# CITY OF ALBUQUERQUE

March 2, 2017

**Re: Winrock Town Center –Red Robin  
2100 Louisiana NE  
Request Temporary-90-Day C.O. - Accepted  
Engineer's Stamp dated: 4-20-16 (J19D058B)  
Certification dated: 2-28-17**

PHASE A - RED ROBIN GRADING PLAN

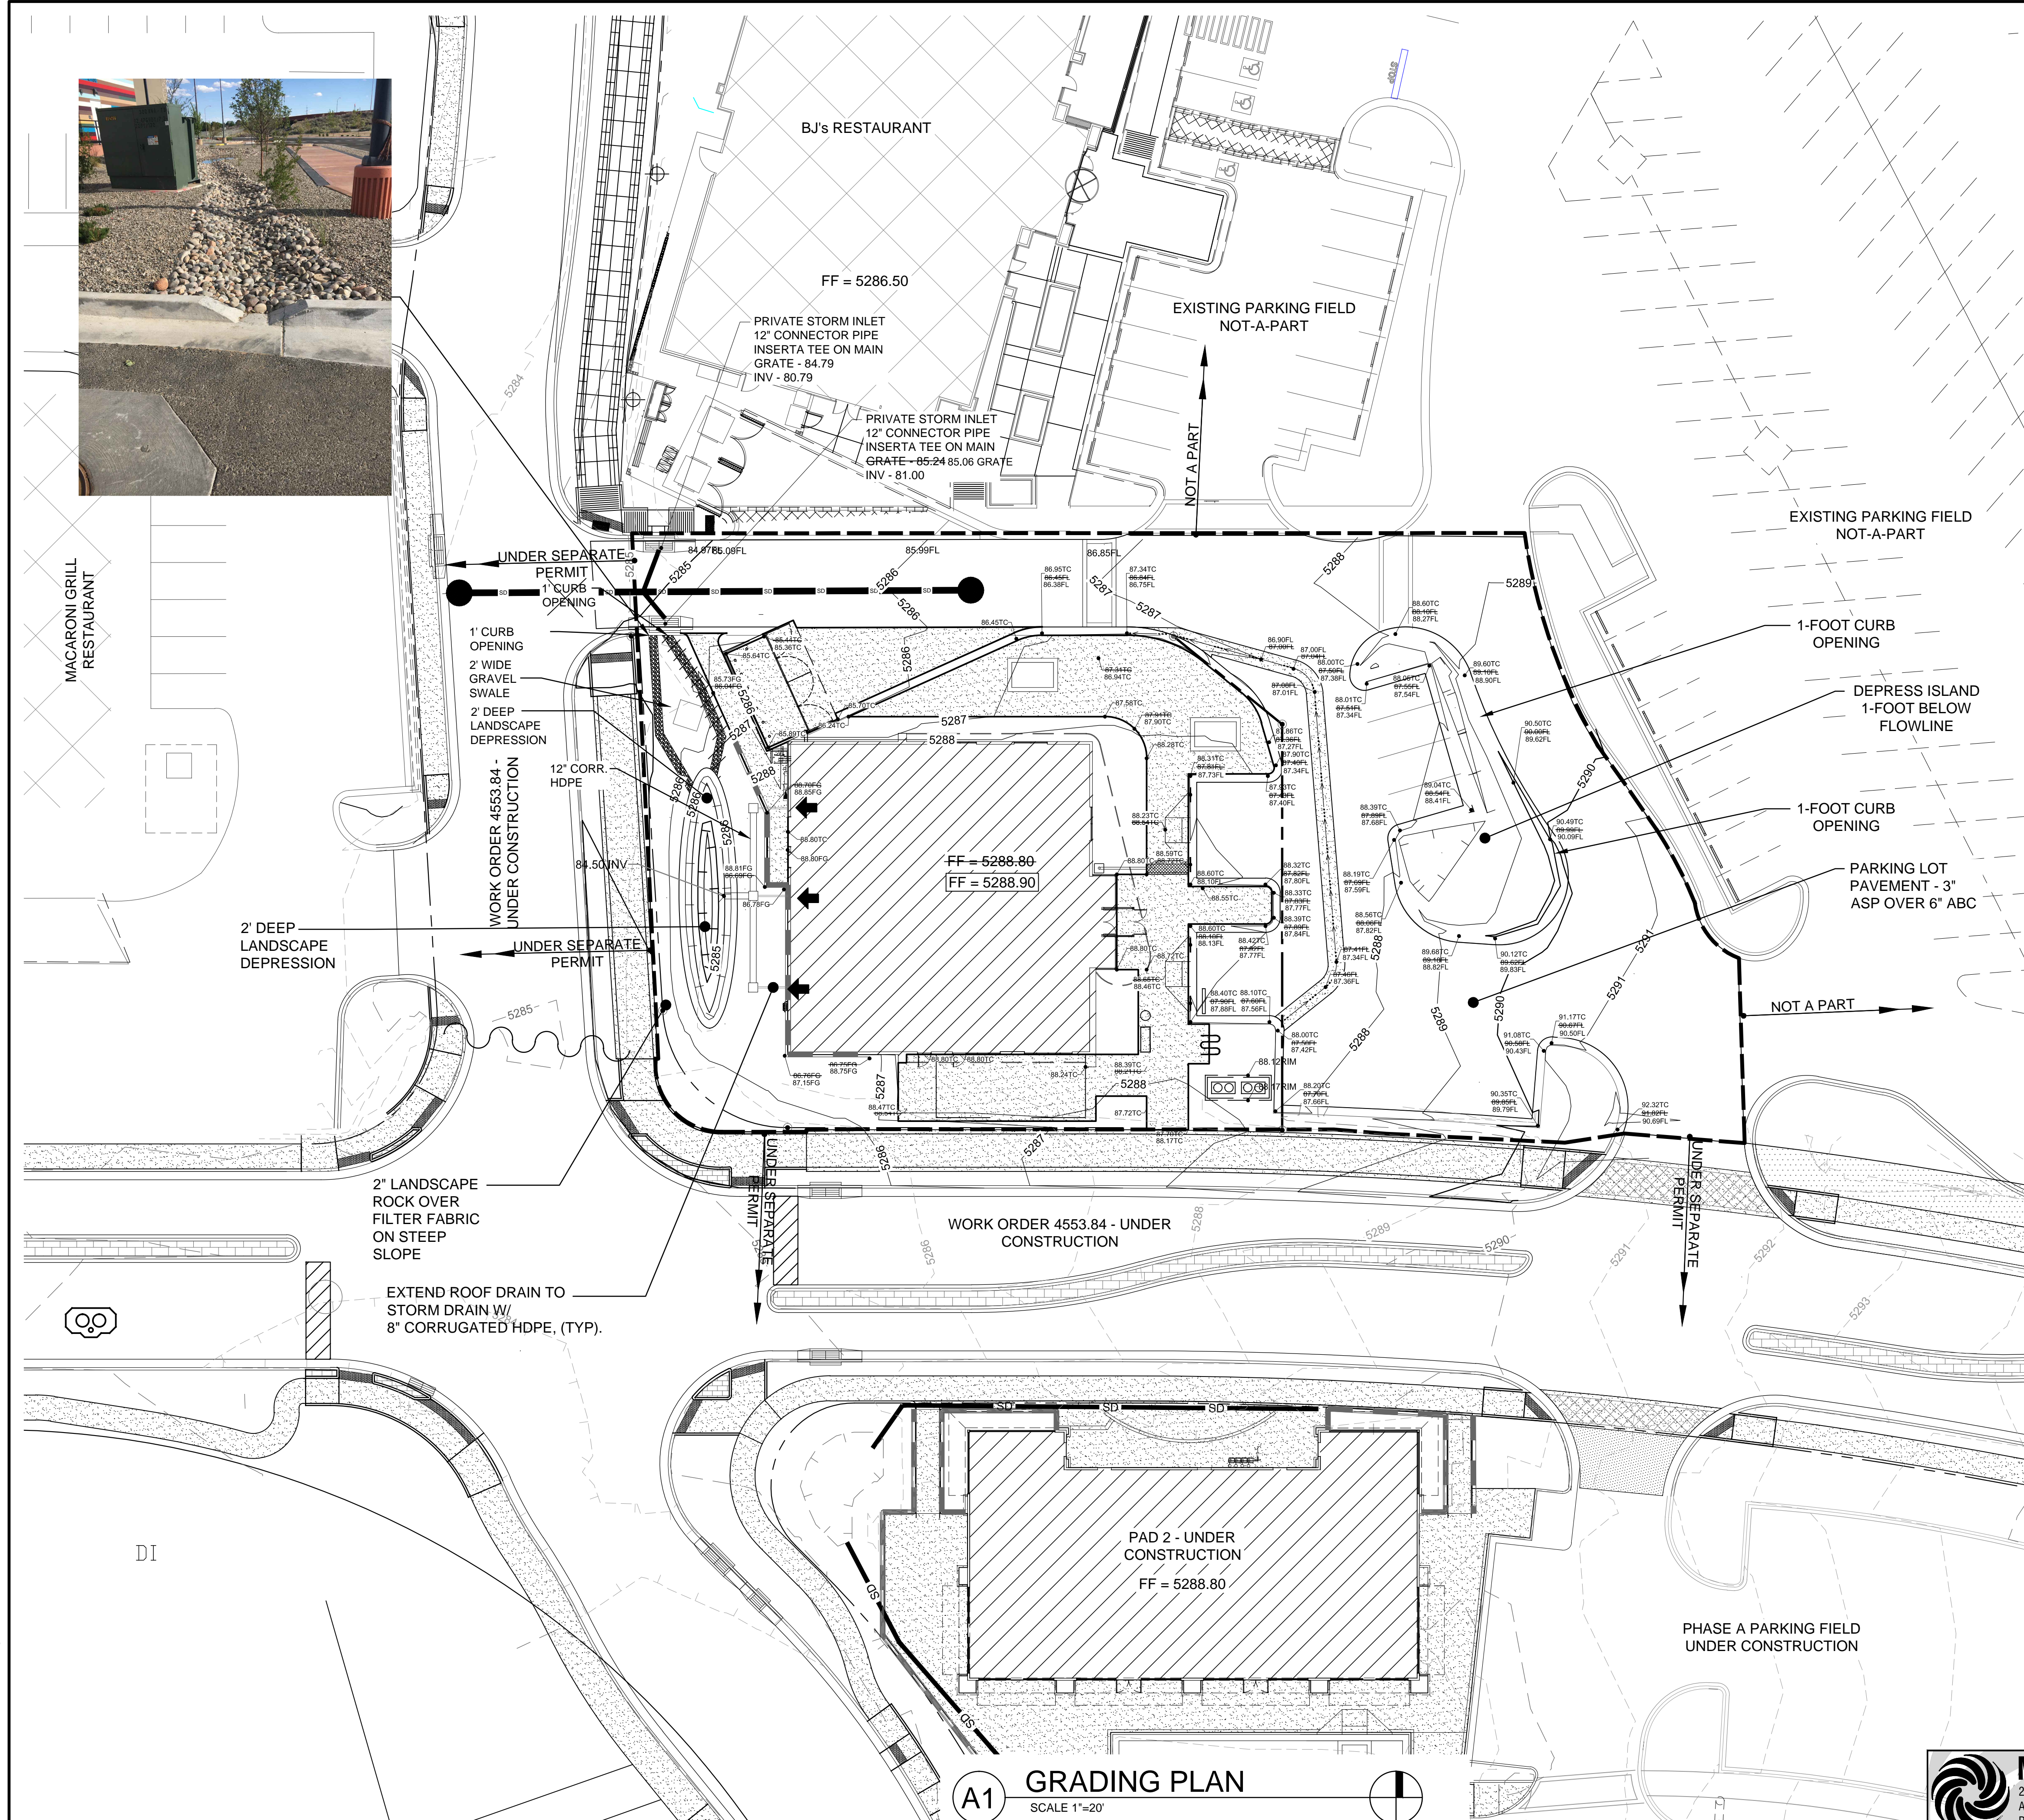
- All 3 curb cuts were missing.
- Depressed island 1-foot below flowline is not depressed.
- Rock swale leading from west pond heading north to curb cut is missing.
- Certification must be integral with drawing. No tape allowed.
